Application No: LU/245/10.

Repositioning of security fencing to boundary of site and security lighting to access road to land on the west bank of the River Arun and construction of additional pontoon moorings.

Land on the west bank of the River Arun Littlehampton

Drawing Number
PL/04

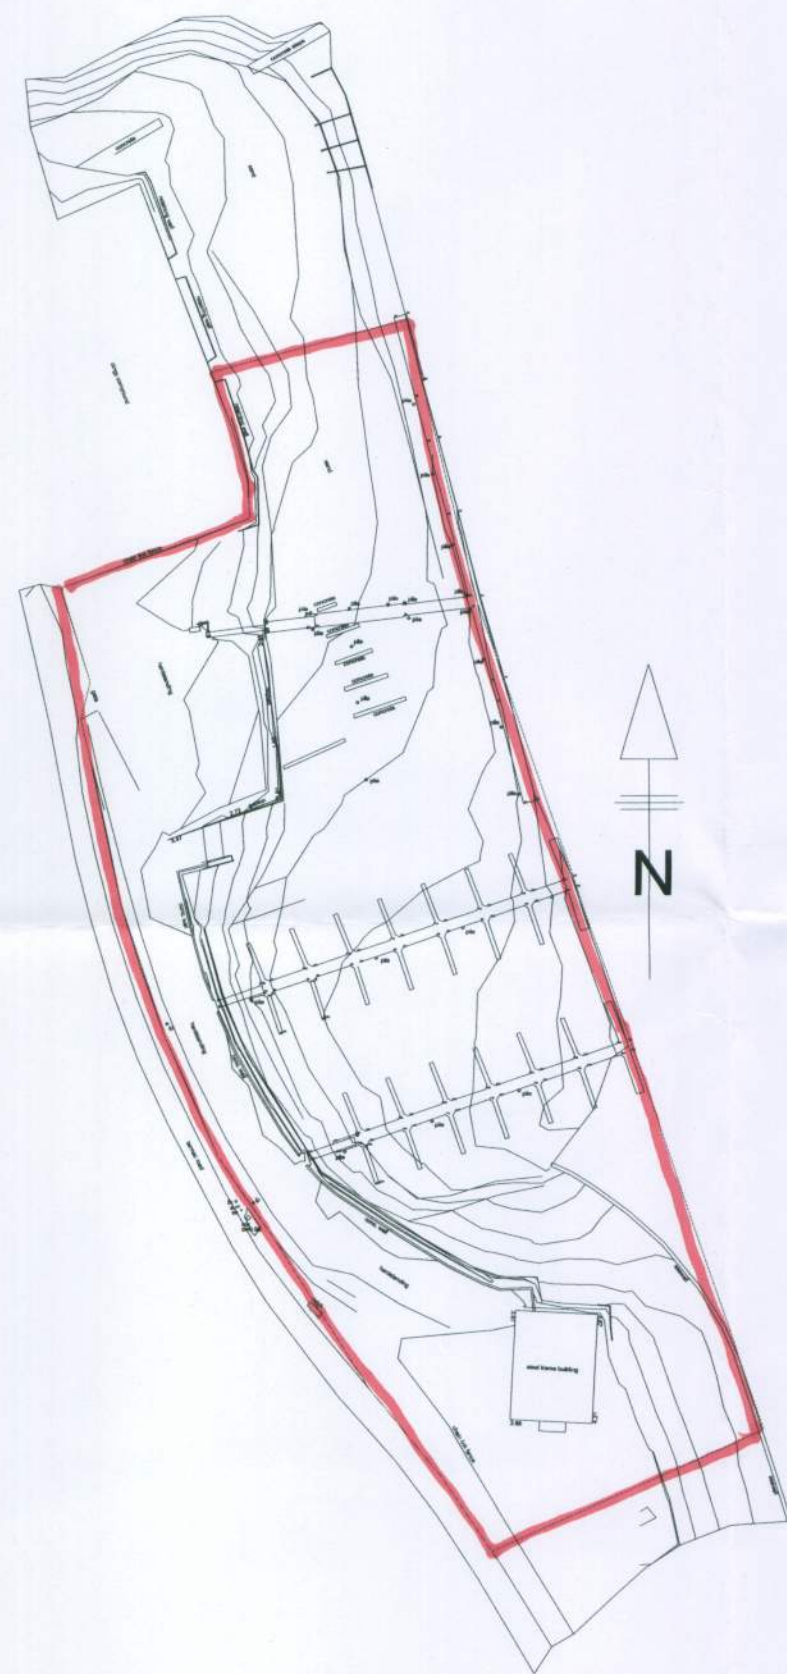
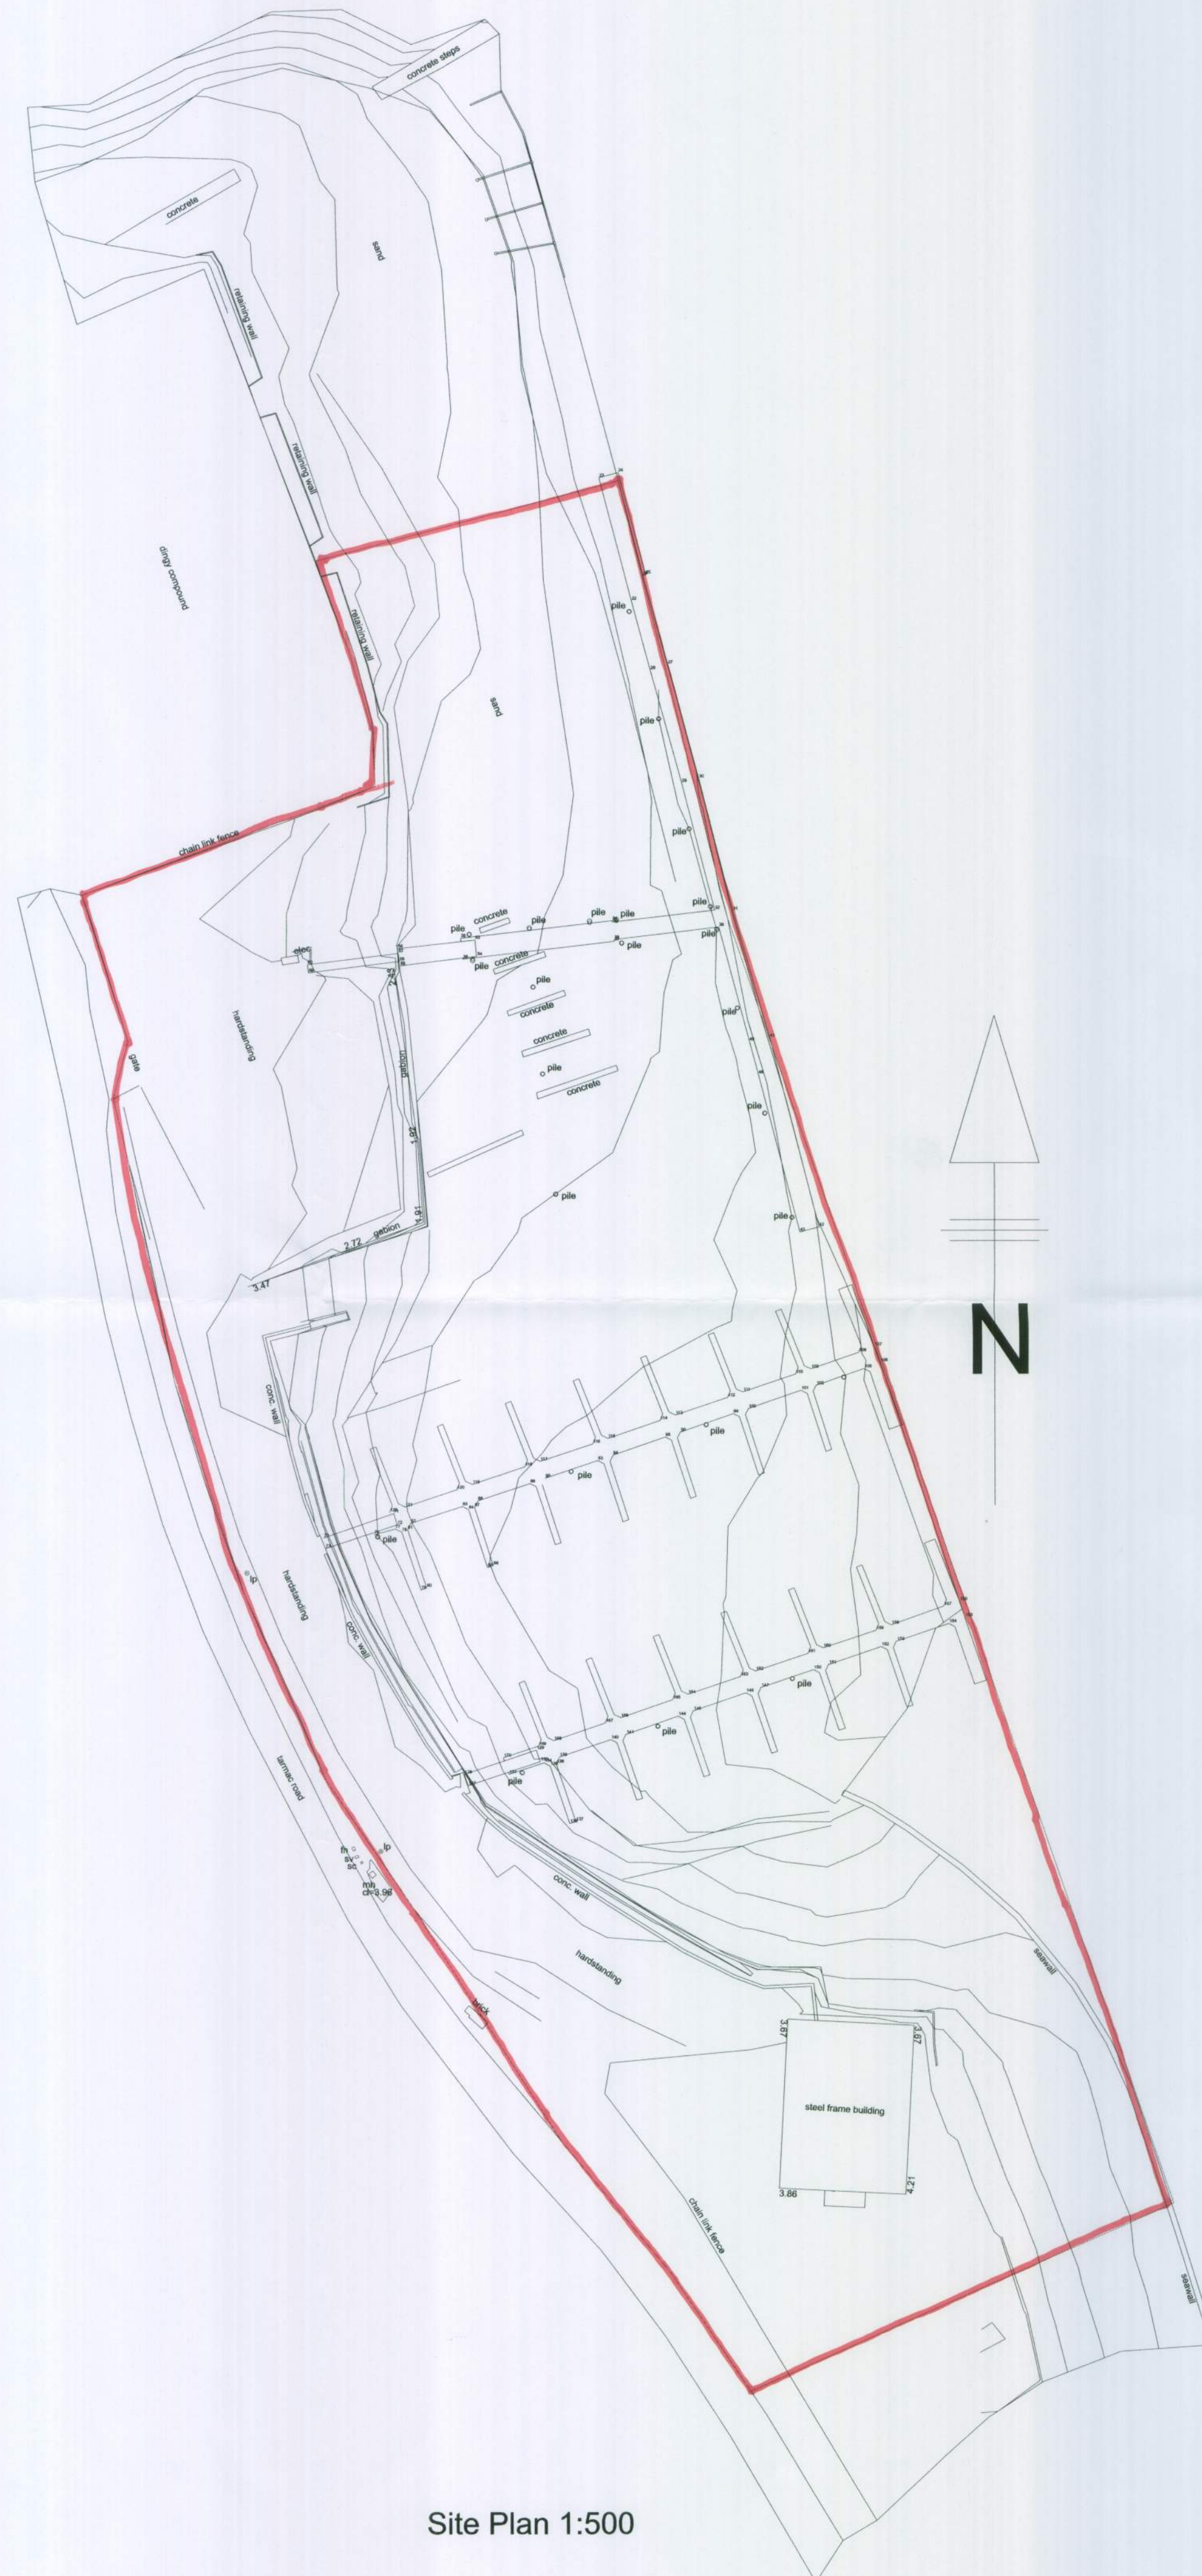
I require 1 electronic or 3 paper copies of a location plan in accordance with the guidance notes available on our website detailed below (click on National List). The site plan needs to be edged in red.

- 1) 3 copies of our drawing Ref. No. 2106/PL/01/1 showing the site plan. This drawing supercedes the previously issued PL/01. The new drawing is based on a complete and accurate electronic survey of the site giving a much improved level of information. It contains all the planning application information held on the original drawing. It also shows the proposed Stage 2 of the mooring layout. As this now makes the drawing too large to fit onto a single A1 sheet it is now divided into 2 sheets showing Stage 1 and Stage 2 of the mooring layouts.
- 2) 3 copies of our drawing Ref. No. 2106/PL/01/2 showing the site plan and details of Stage 2 of the mooring layout. (see above)
- 3) 3 copies of our drawing Ref. No. 2106/PL/04 showing the site and location plans.

## RIVER ARUN

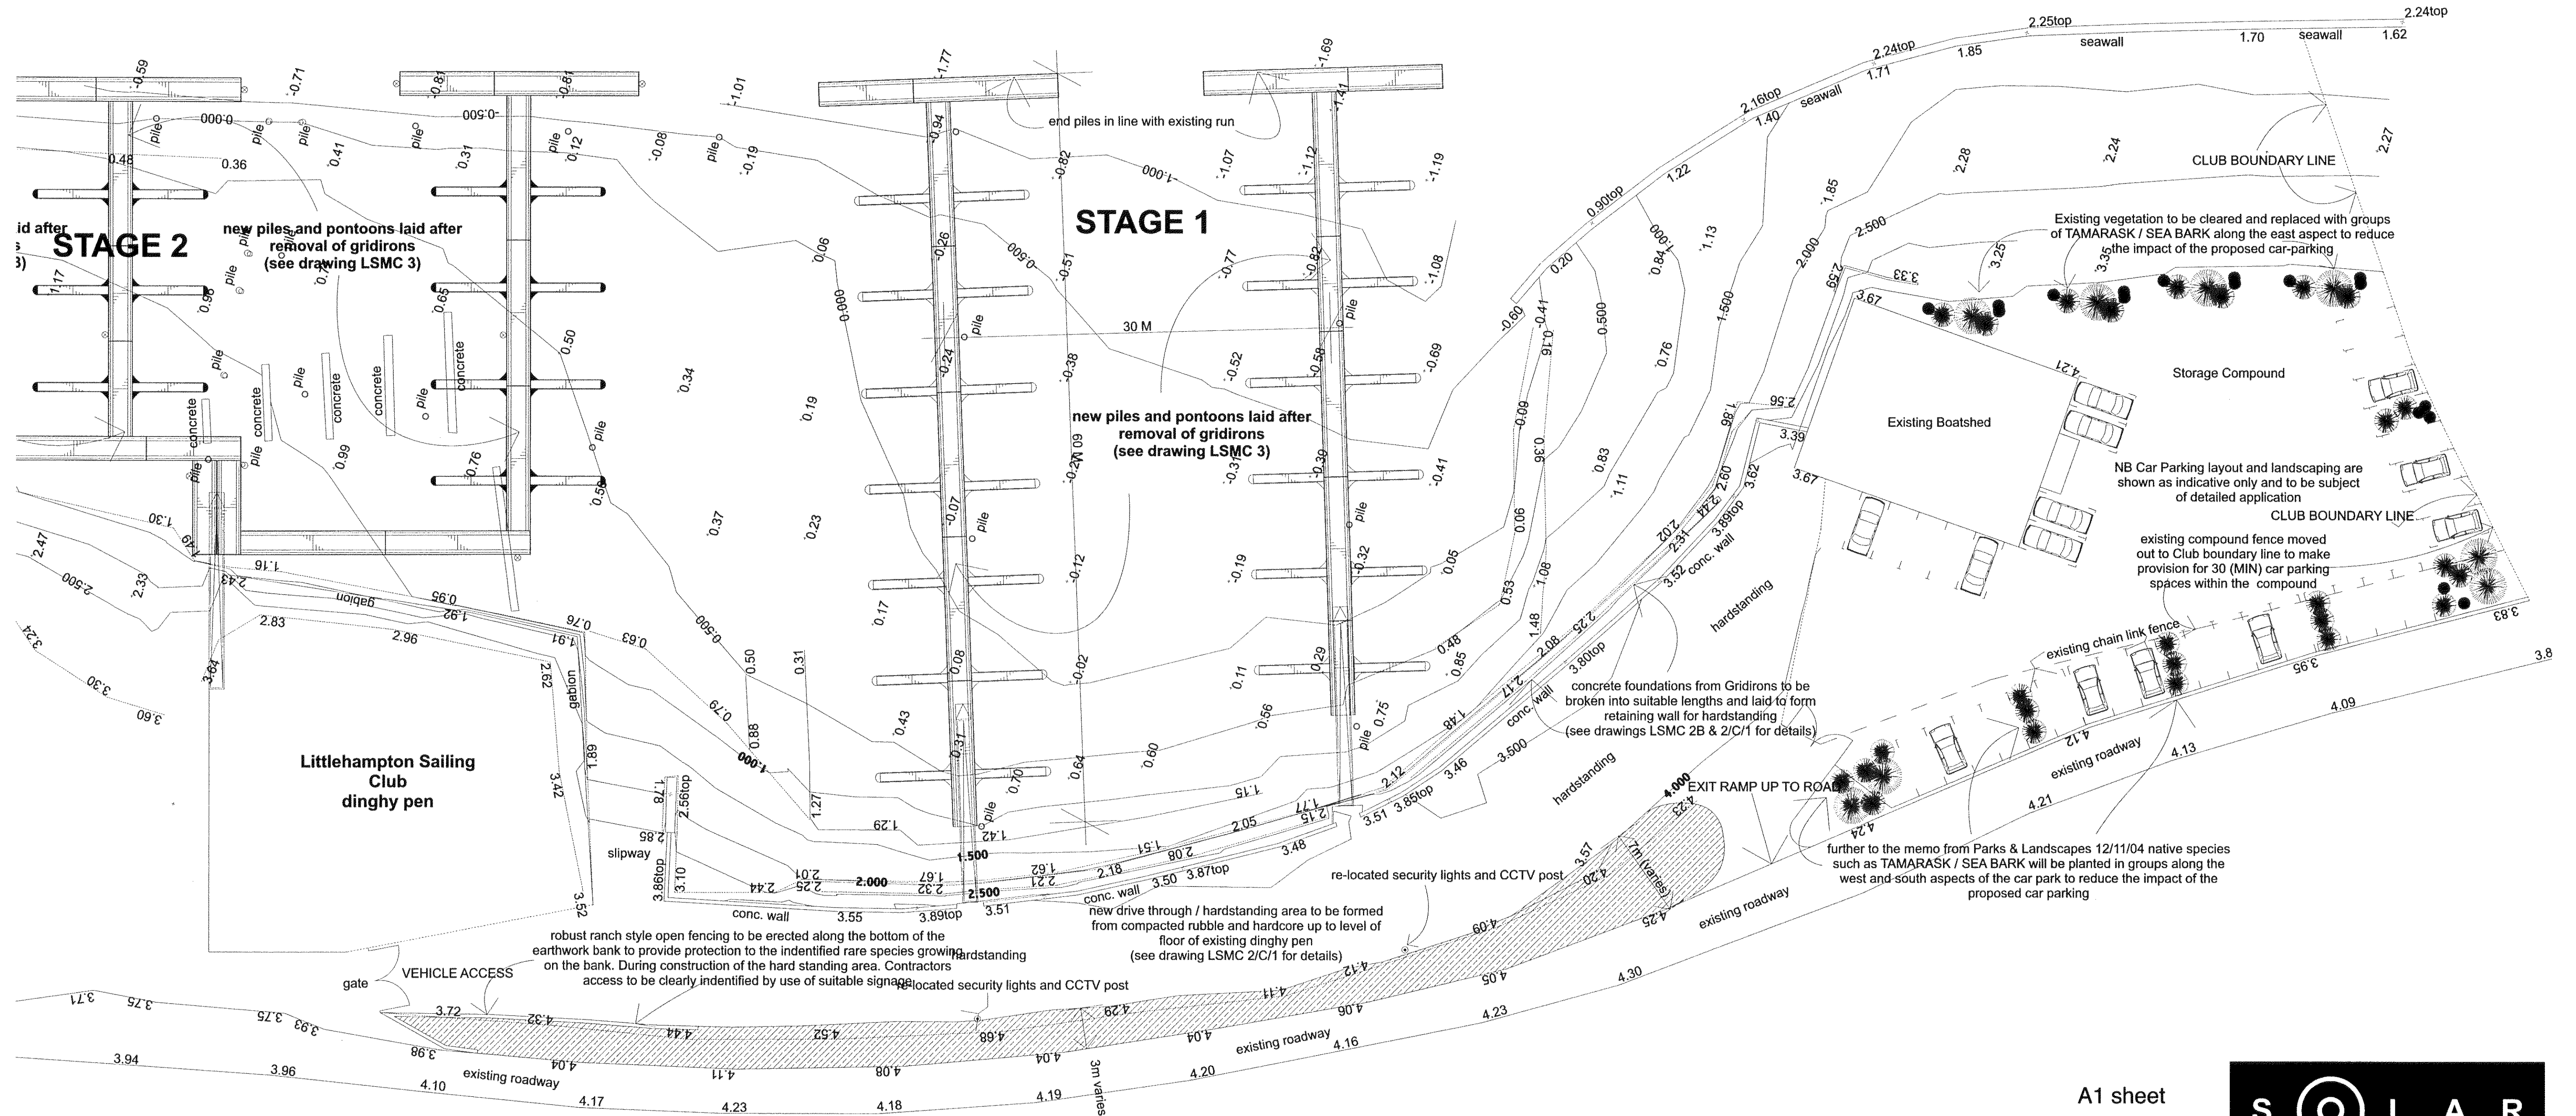
Will the security lights be on for the entire dark period? Operated by movement sensors? Please provide details of the light spill profile?

It is not clear where security fence is being moved to and from where. Likewise the security lighting.

Please provide details of the fence design and its relationship to the bank to be protected? I.e. will the bank be damaged?

I will check to say how the security lights are being operated and seek to obtain a light spill profile . My understanding is that the security fencing is being extend from its original position at the main entrance to the site. I will check this also.

I will check to determine the impact of the fence on the bank.

Further to this e-mail and our 'phone conversation of 18th July we attach revised copies of our drawing ref. nos. **2106/PL/01/1** and **2106/PL/01/2** showing revised proposed planting types together with a data sheet for the flood lighting.

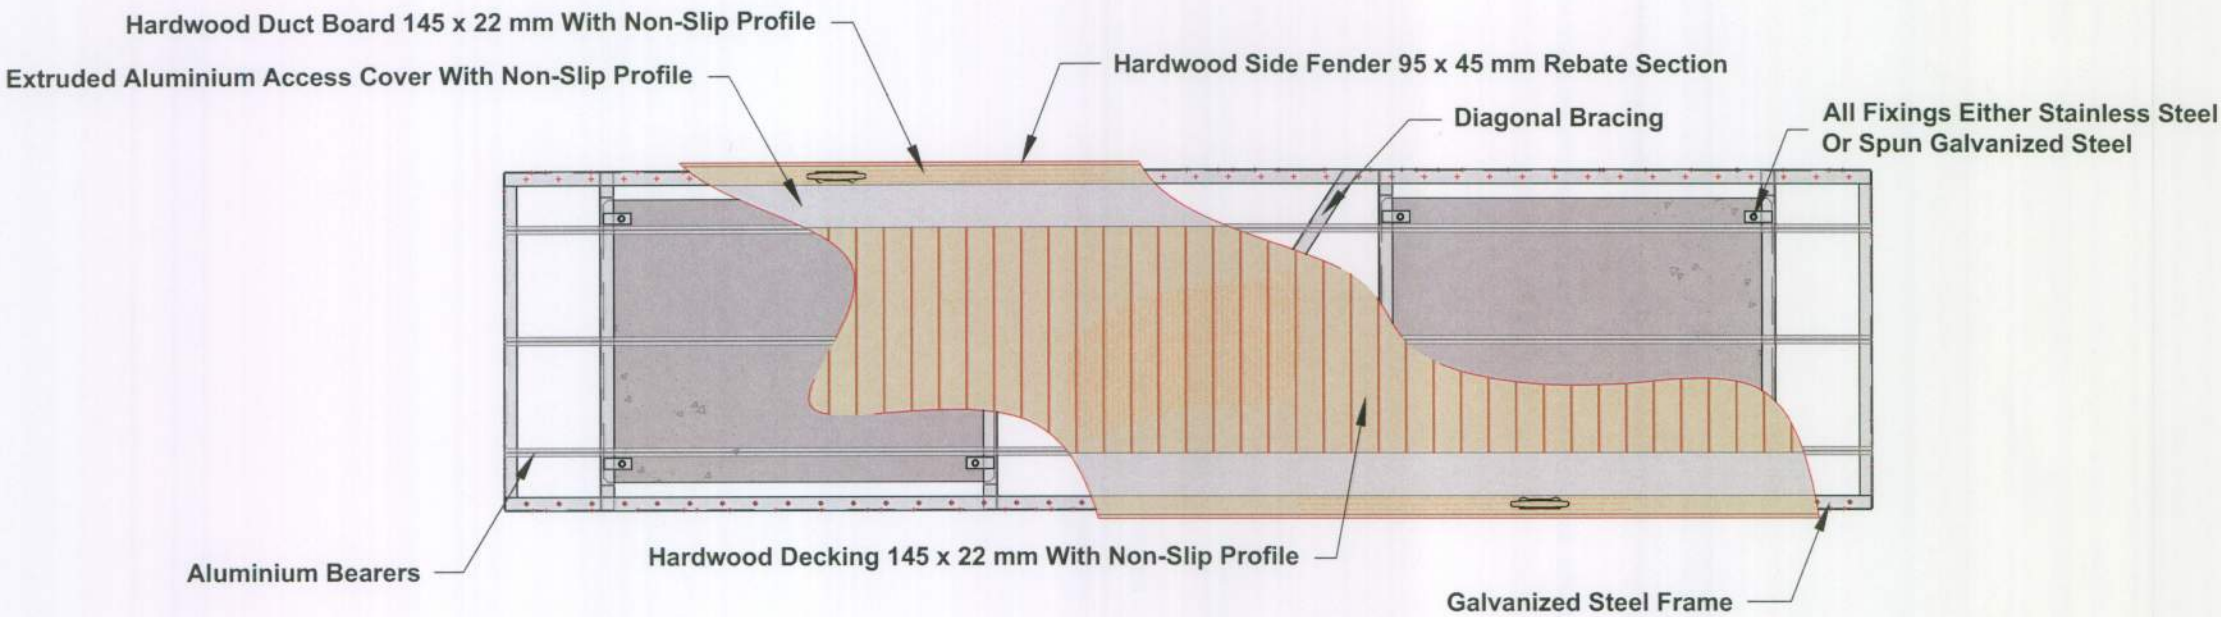
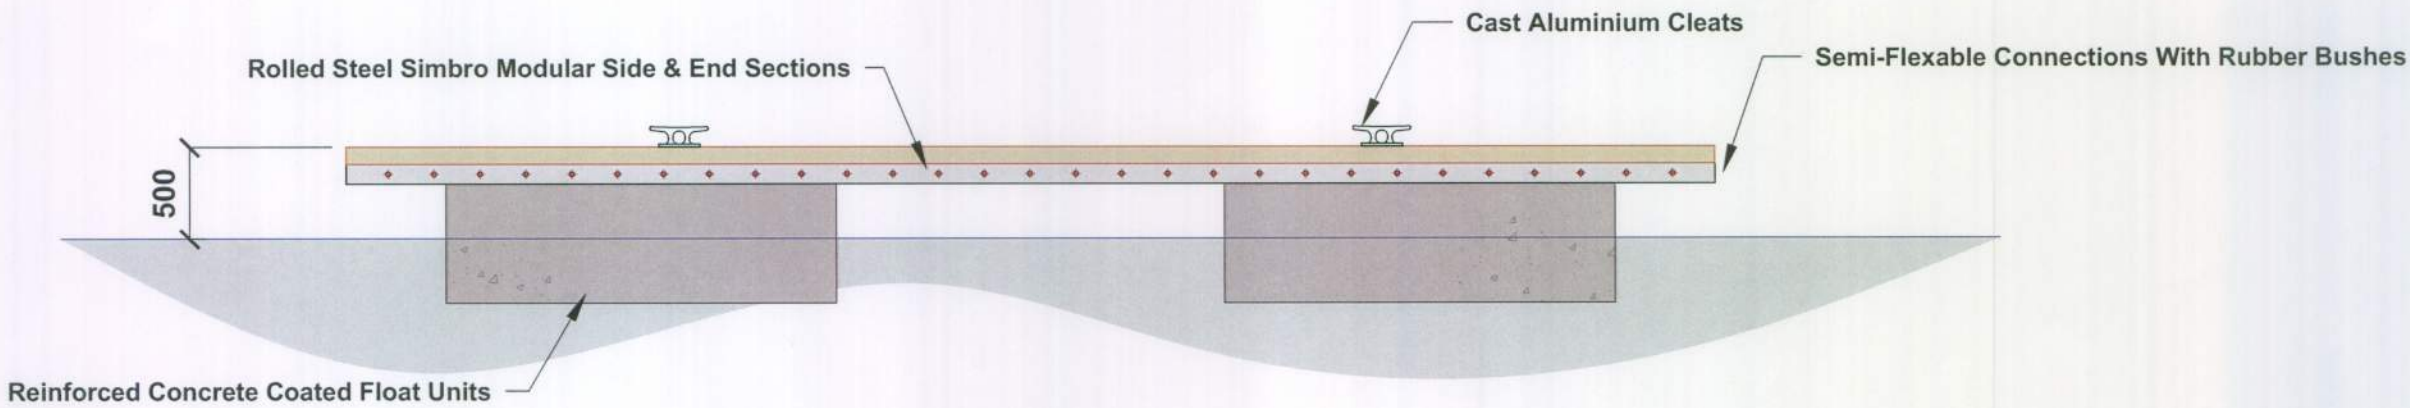
Which are the additional pontoons?

Further to our 'phone conversation of today's date please
find attached as discussed technical details for the pontoon
system for the moorings at Littlehampton Sailing Club.
